Our Ref: SDNP/20/02157/ADJAUT
Contact Officer: Nat Belderson

Neighbouring Authority Consultation

Proposal: Adjacent Authority Consultation - A/76/20/PL - 84 No. dwellings, public open space, play areas, associated infrastructure & landscaping. This application affects a Right of Way.

Address: Land at Dapers Lane , Angmering, ,

Outdoor Lighting Report

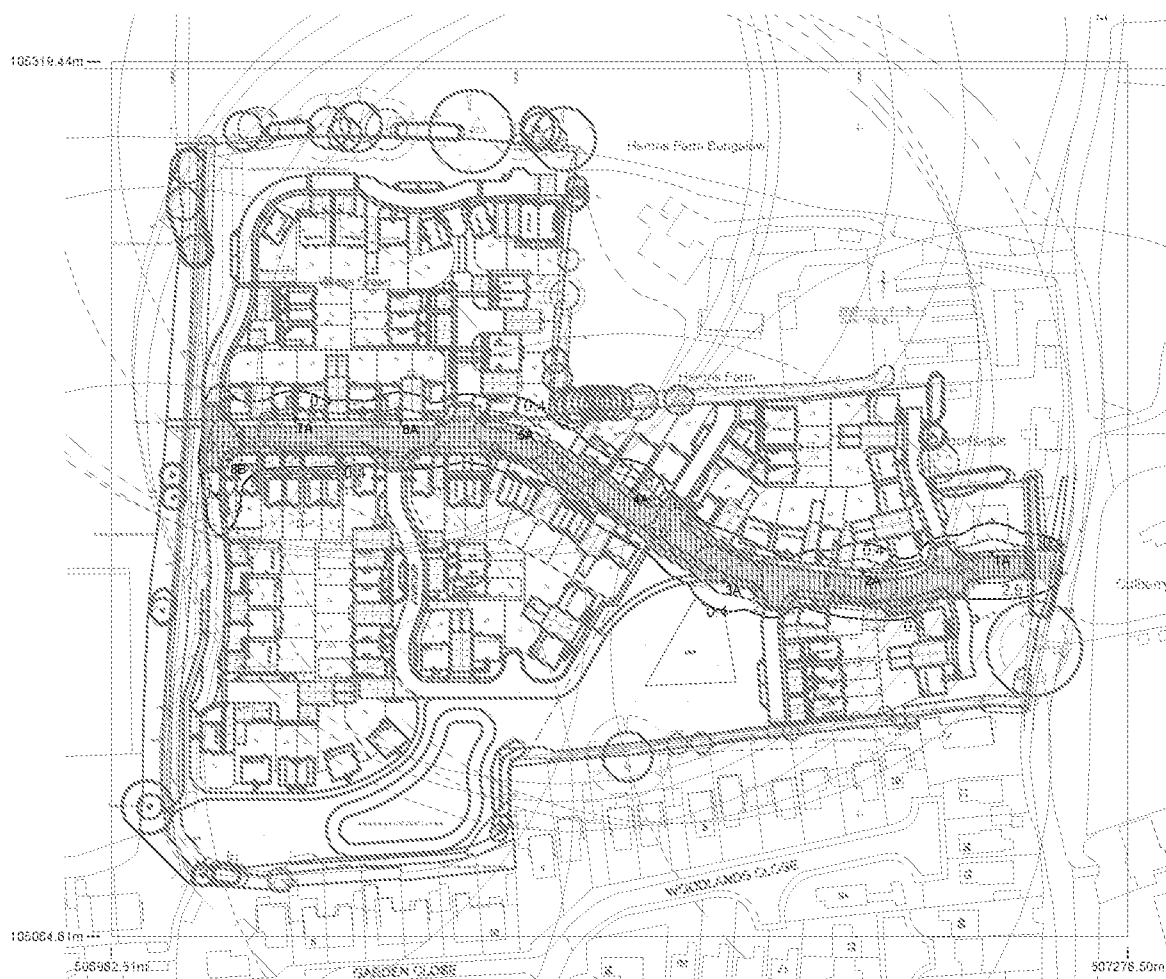
The SDNP is designated as an International Dark Sky Reserve. Details of roadway/outdoor lighting have been provided with the application, and we request that these details be ensured via a condition, once the District Council is satisfied that all opportunities to reduce light pollution have been taken.
